From: Fiona Fitzgerald <Fiona.Fitzgerald@arun.gov.uk>
Sent: 30 May 2022 11:29
To: Planning.Responses <Planning.Responses@arun.gov.uk>
Cc: Maria Tomalova <Maria.Tomalova@arun.gov.uk>
Subject: P/82/22/PL

Drawing **PROPOSED SITE/BLOCK PLAN**

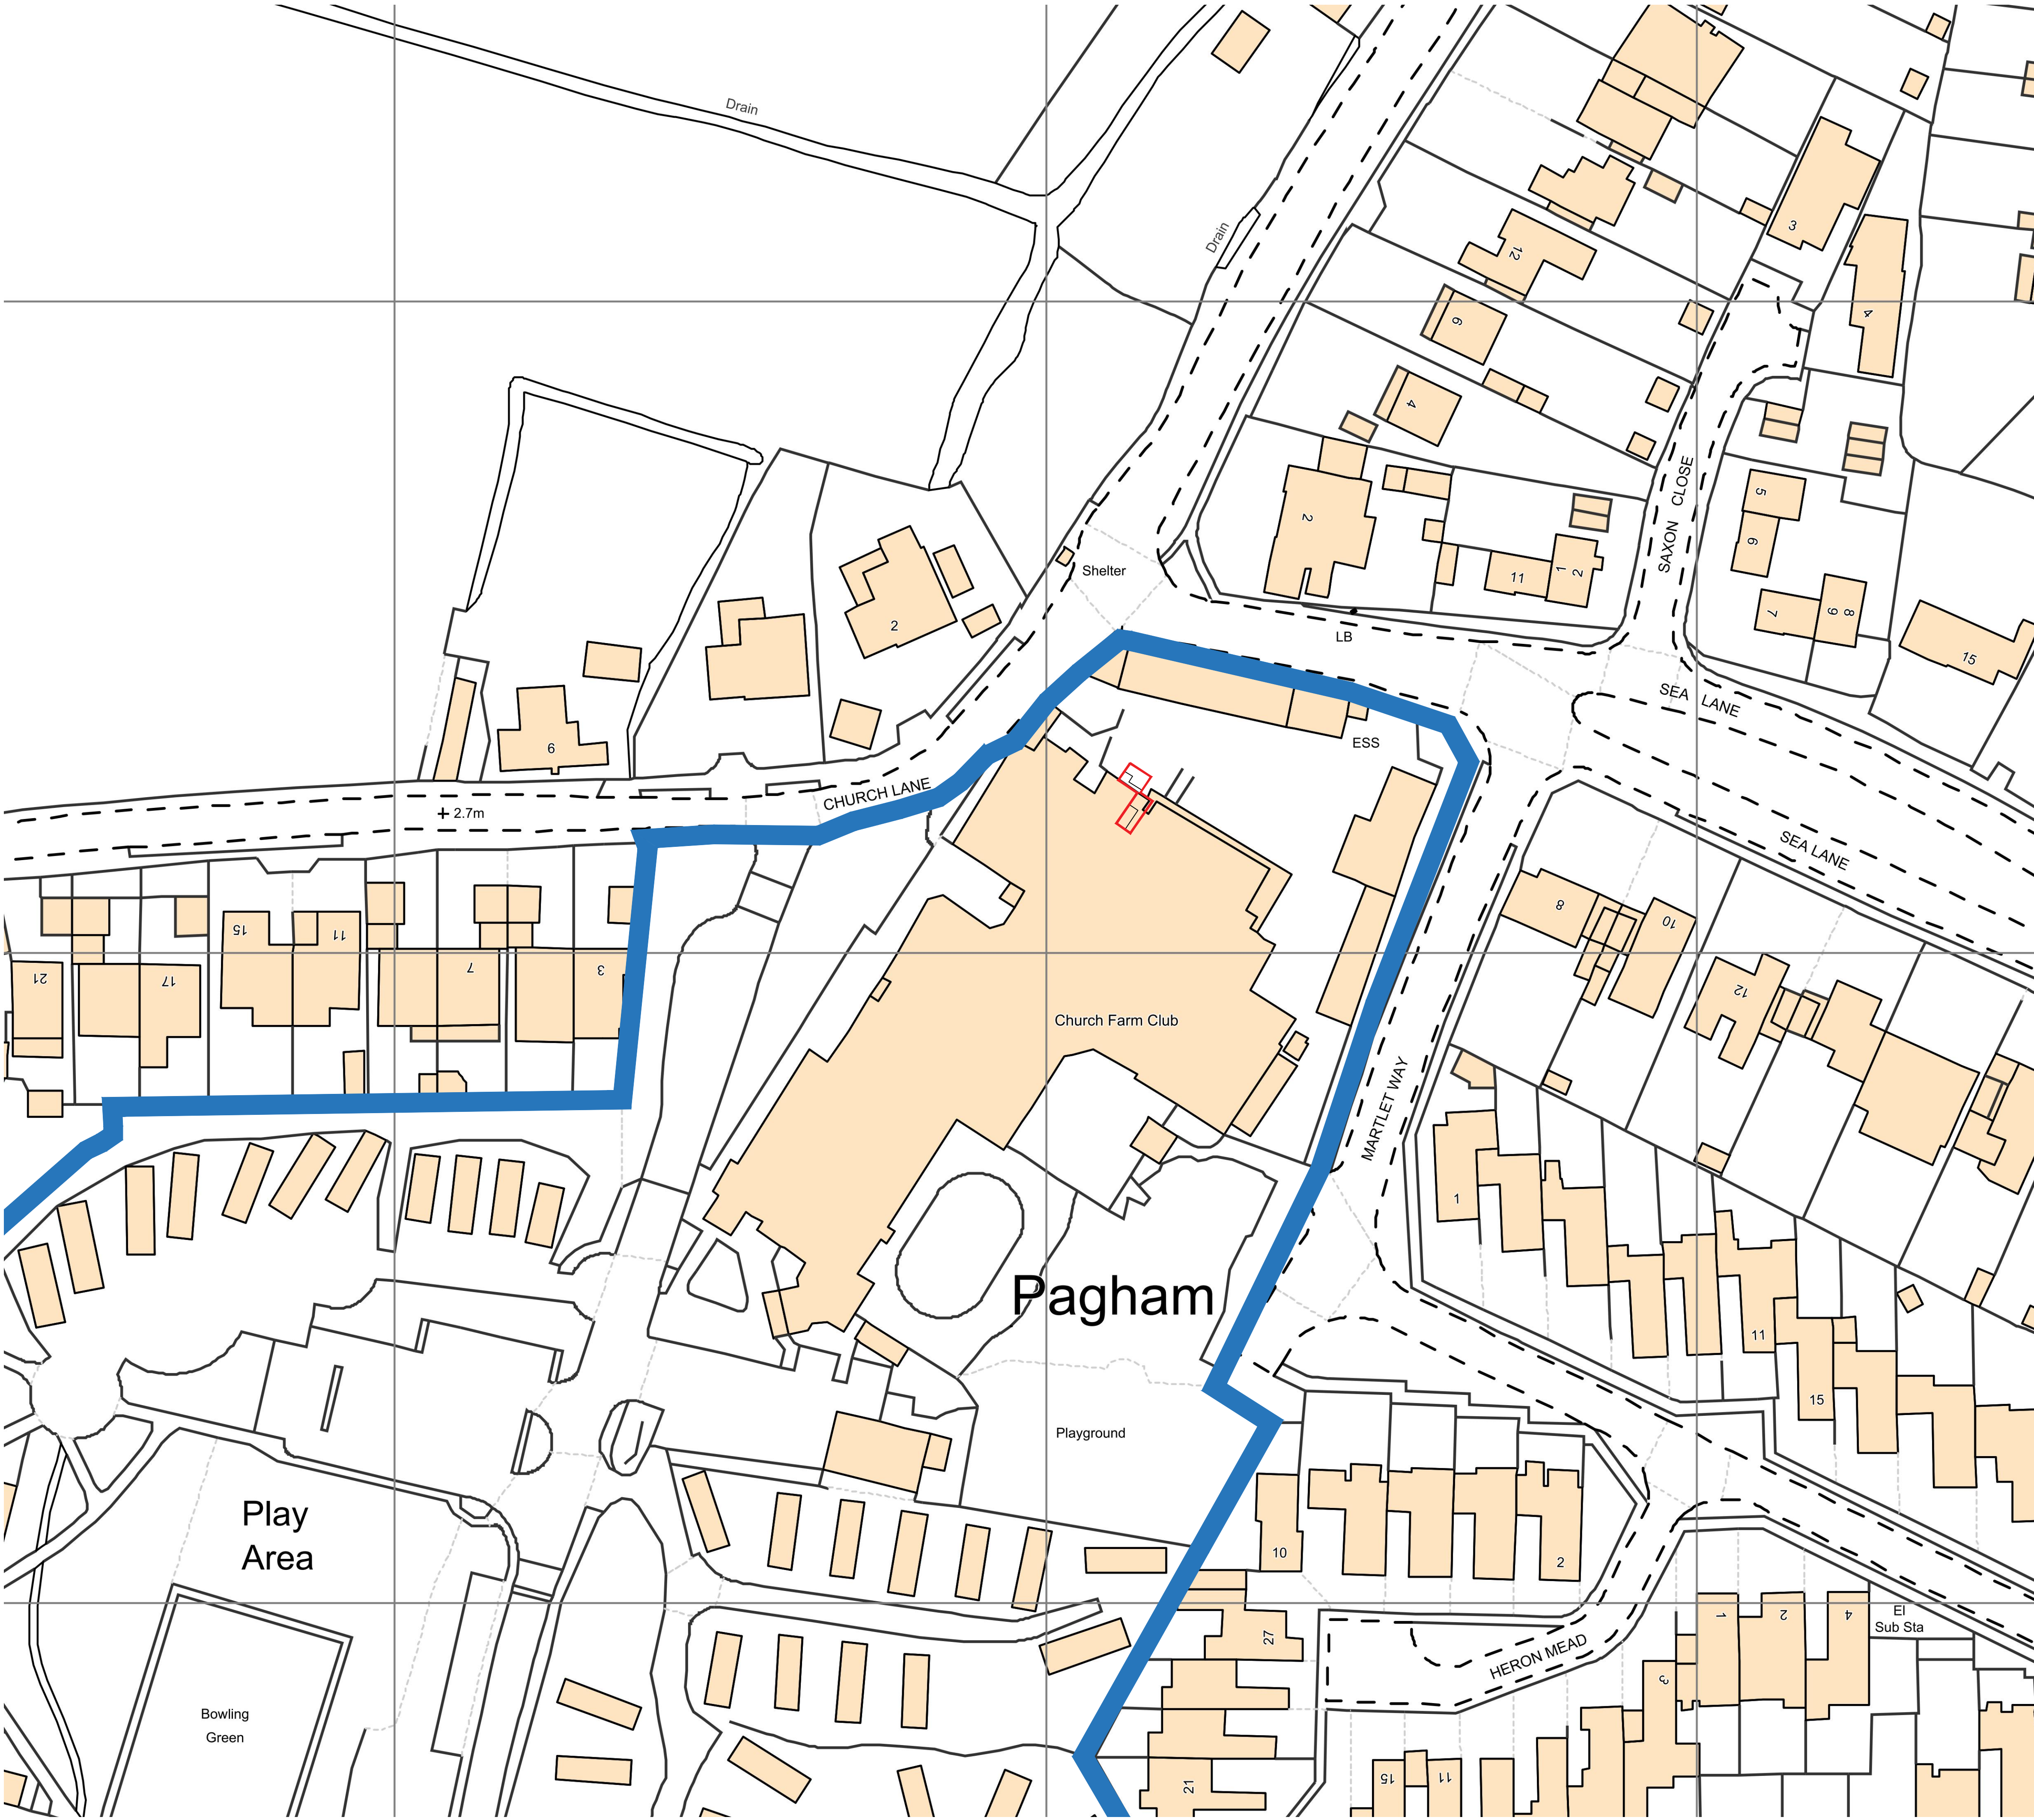
Please could the applicant confirm whether noise from the unit has been taken into account when siting this unit? Whilst I note that the acoustic data has been provided in the manufacturers specifications, I am unsure which way round the unit will be faced, and whether the residential dwellings over the road have been taken into account when siting the unit?
